Date: 12 October 2017

Land West of New Barn Lane Bersted: Application for Approval of Reserved Matters (BE/133/17/RES)

We write on behalf of our client, The Church Commissioners for England ("Church Commissioners"), in relation to the above application. The Church Commissioners owns the land immediately south of the application site, and currently has an outline application (with all matters reserved) for 50 dwellings pending the decision of the Secretary of State.

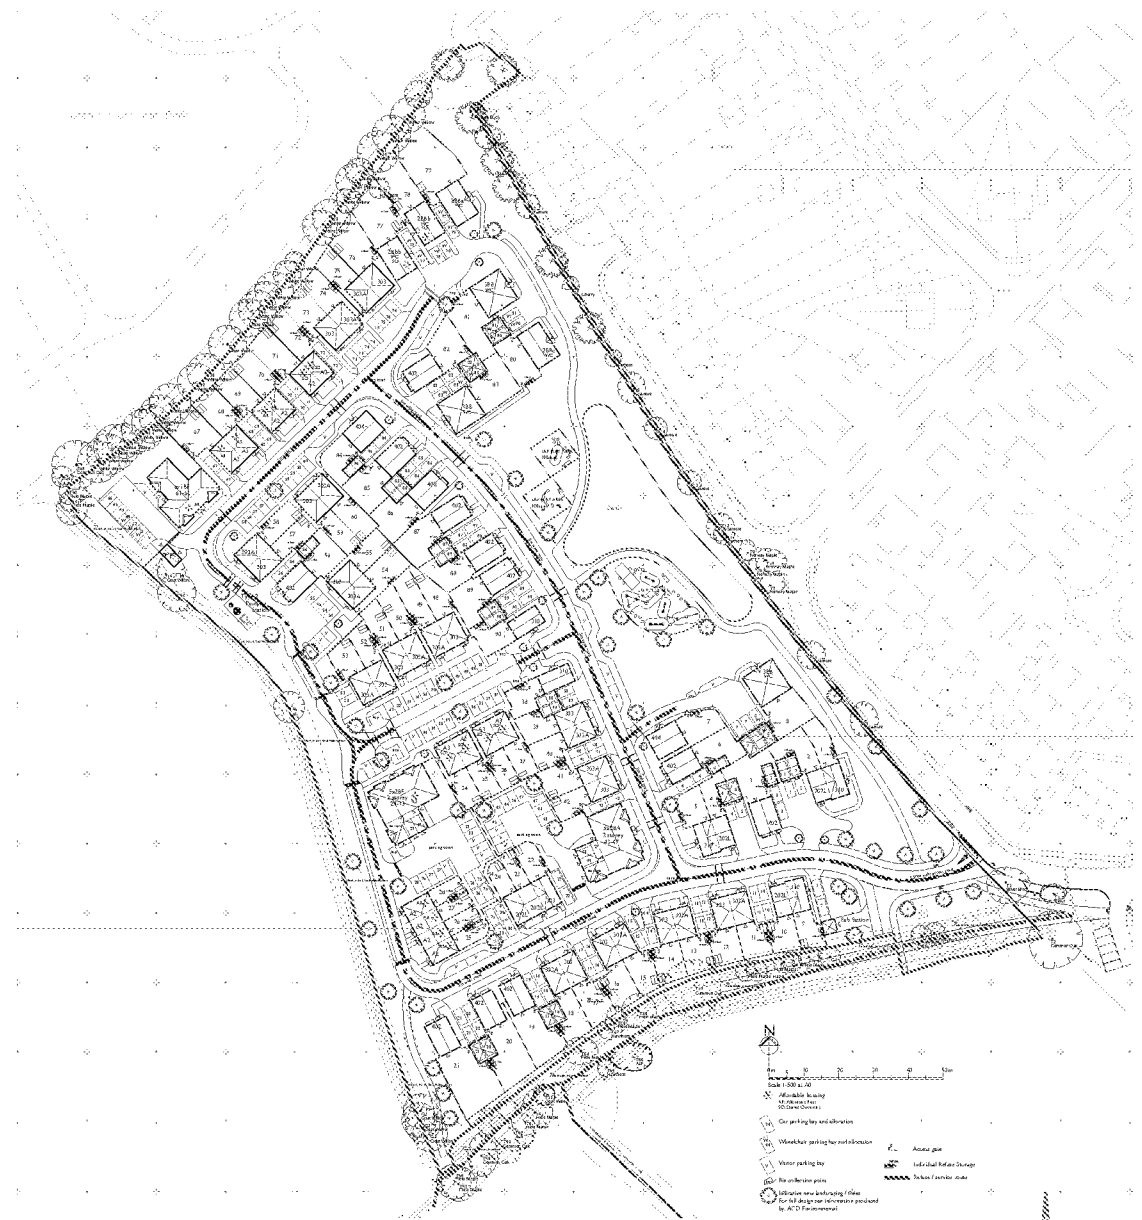
We are pleased to see development coming forward on the Land West of New Barn Lane and are supportive in principle. In particular we welcome the inclusion of a spur road leading south via the proposed substation off the entry road in the southeast corner of the site (drawing ref. 16-1103-005).

While the currently proposed spur could provide access to the Church Commissioners' site, we consider that to optimise pedestrian and vehicular access it would benefit from being widened to 5.5m with the provision of pavements of 2.0m width on either side. This would provide an optimum width, consistent with Manual for Streets 2 guidance and in line with the provision to the Linden Site, linking the two developments to one access point and allowing development to be brought forward comprehensively.

We respectfully request that this change is made to facilitate the comprehensive development of both sites.
